From: Simon Davis
Sent: 02 April 2020 17:54
To: 'Lauren Wiltshire'
Subject: RE: FP-171-18-PL 6 Wellers Close

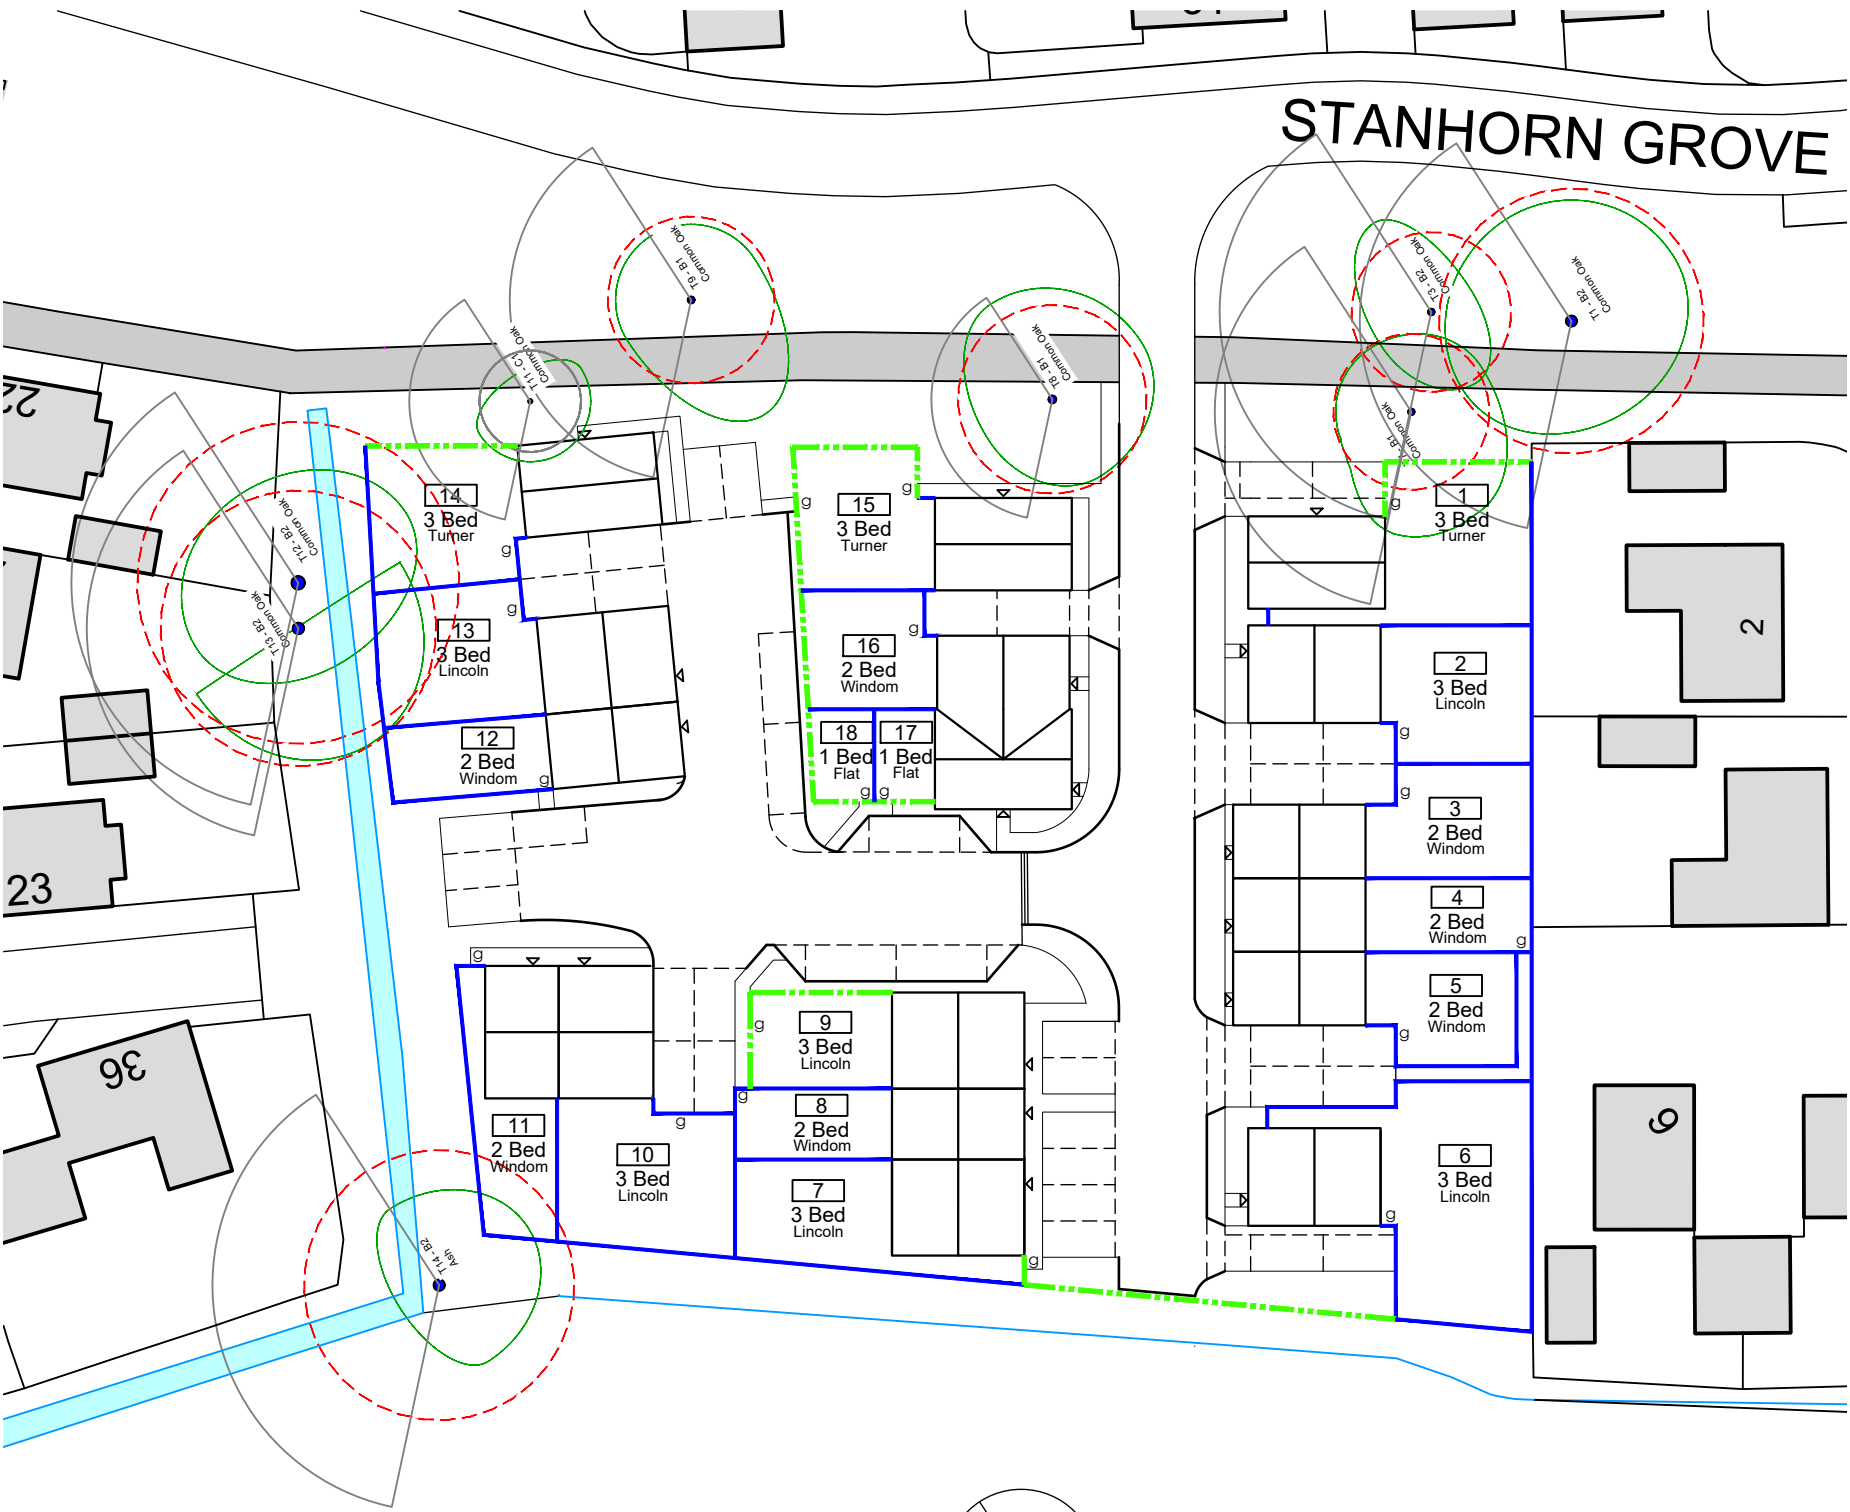
Thank you. I would recommend that you proceed with your proposed 1.8m high fence. However, you may want to consider adding gravel boards as I will have to advise neighbouring residents that they may have grounds for civil action if their existing fences are damaged as a result of the development.

Please can you advise how much you would have spent on the new boundary fence and also what the cost of replacing the existing fence (to a height of 1.8m) would be? If there is a significant difference, then you could talk to Mr Cooke to see if he and his fellow residents will pay the difference.

In regards to the fencing the new fence that was going to be installed was going to be at 1.8m high, so it would have been up to the adjoining residents if they wanted to remove their own fences on their side they could have done so.
